Please ask for: Nicola Moore
Email: nicola.moore@arun.gov.uk
Telephone: Ext 37944
Our Ref: AW/104/21/PL
Your Ref:
Date: 25th March 2021

Application for Planning Permission

Development: Single storey rear extension, loft conversion, alterations to fenestration, and part change of use to cafe on ground floor and office on first floor level.
Location: 97 Aldwick Road Aldwick PO21 2NY

Drawing No.	Date:
D.1091 - 06	04-03-21
Rev.	Date:
A	27-03-21

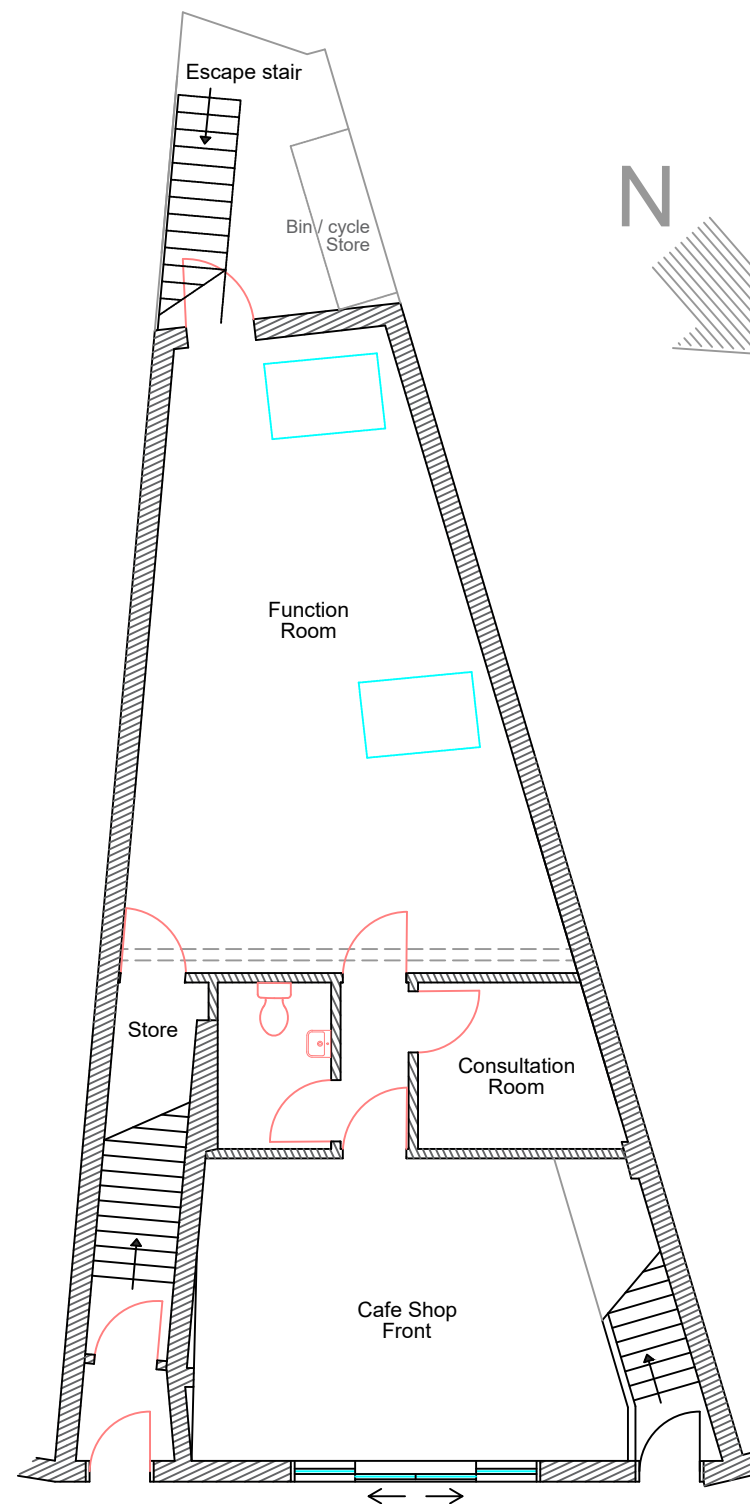
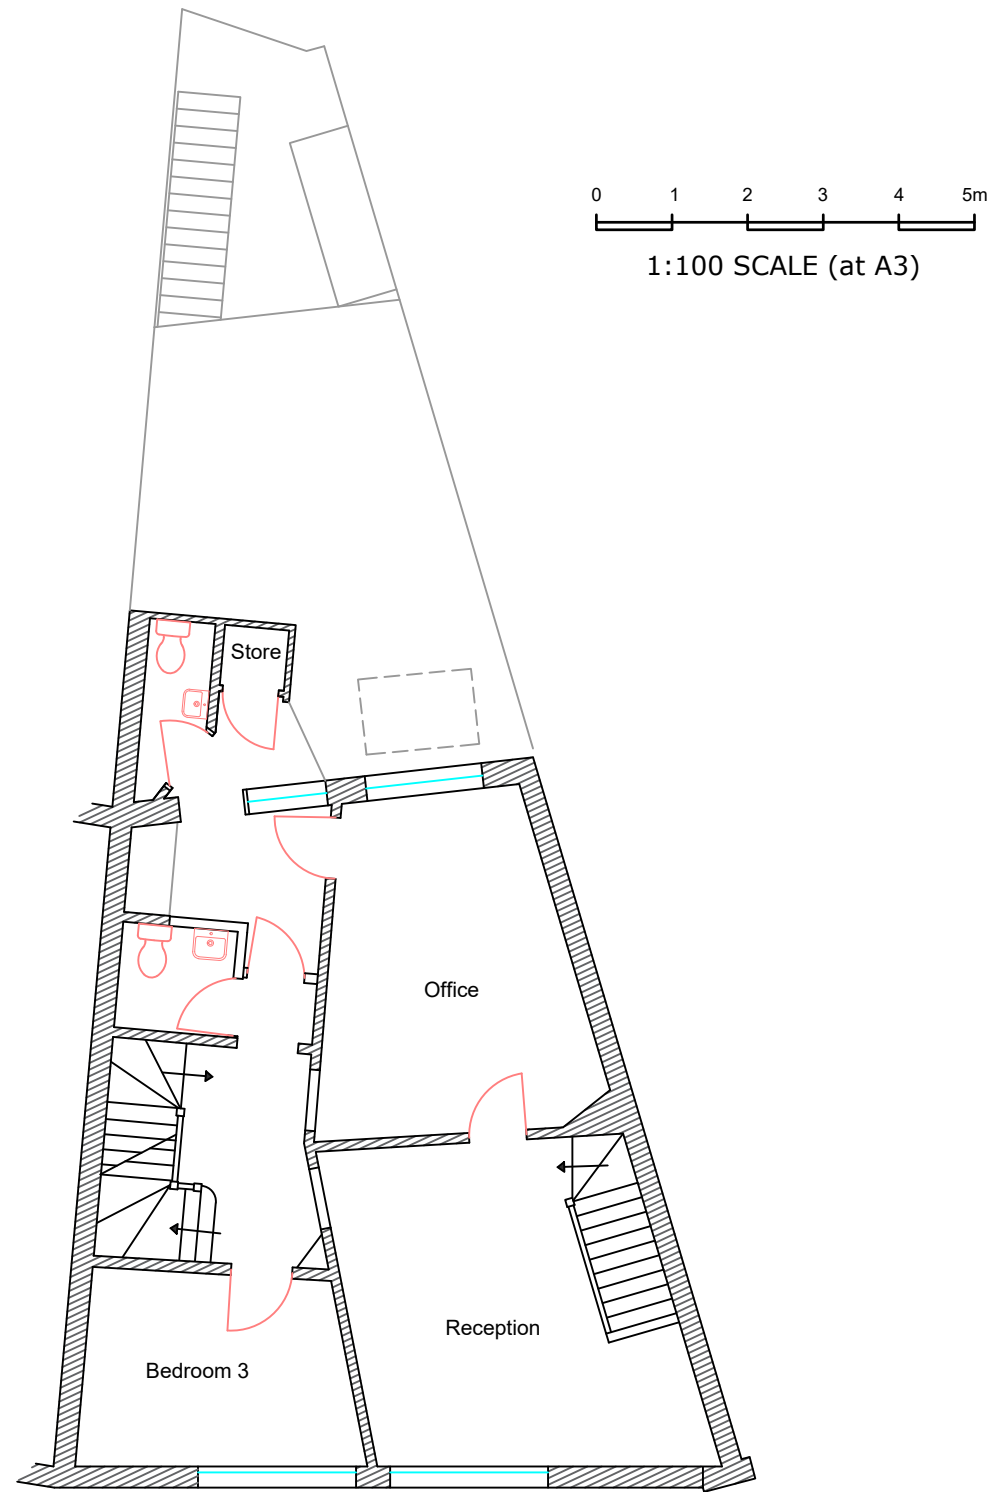
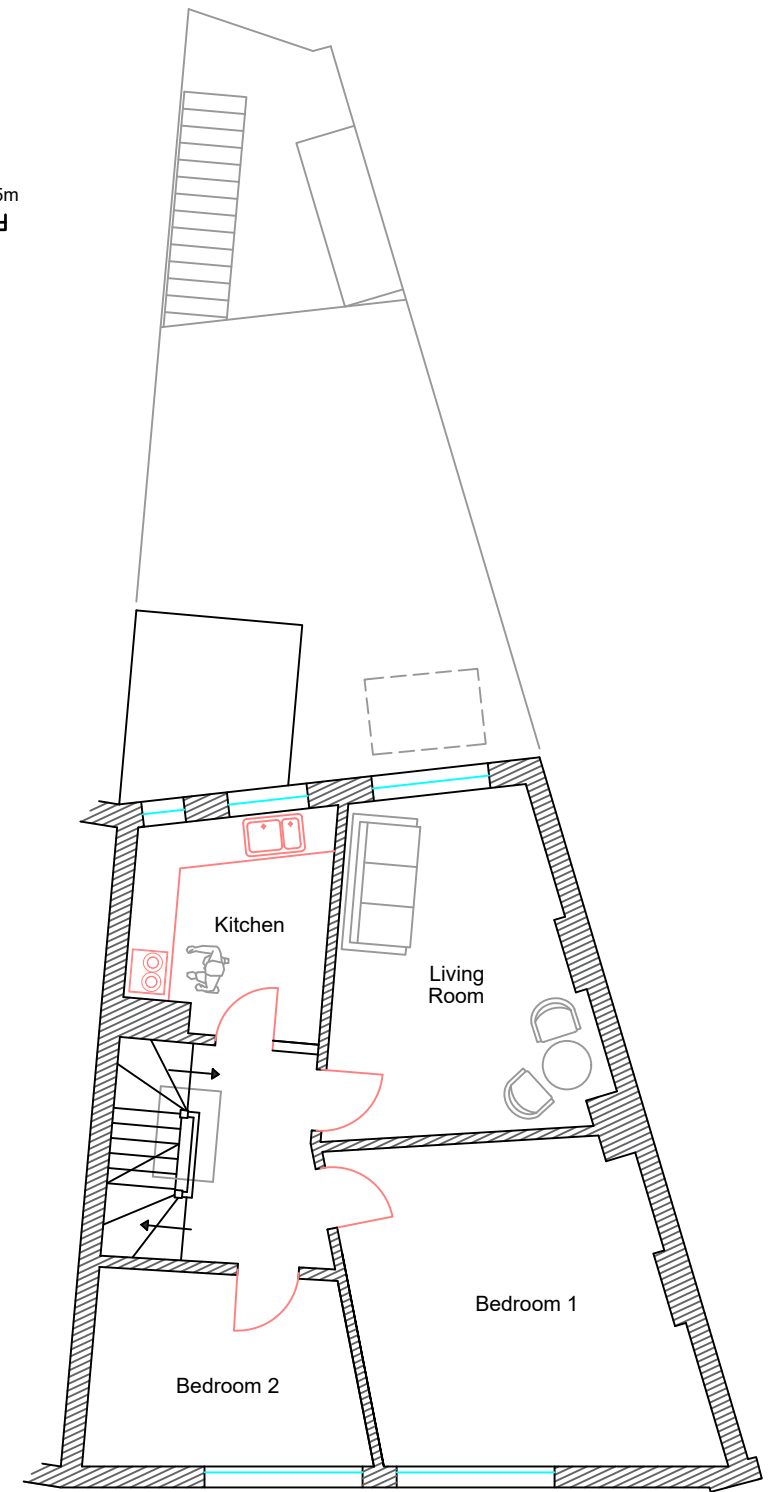
Floor Plans

The proposed floor plans show 2 x Bedroom 2, please amend accordingly and re submit.
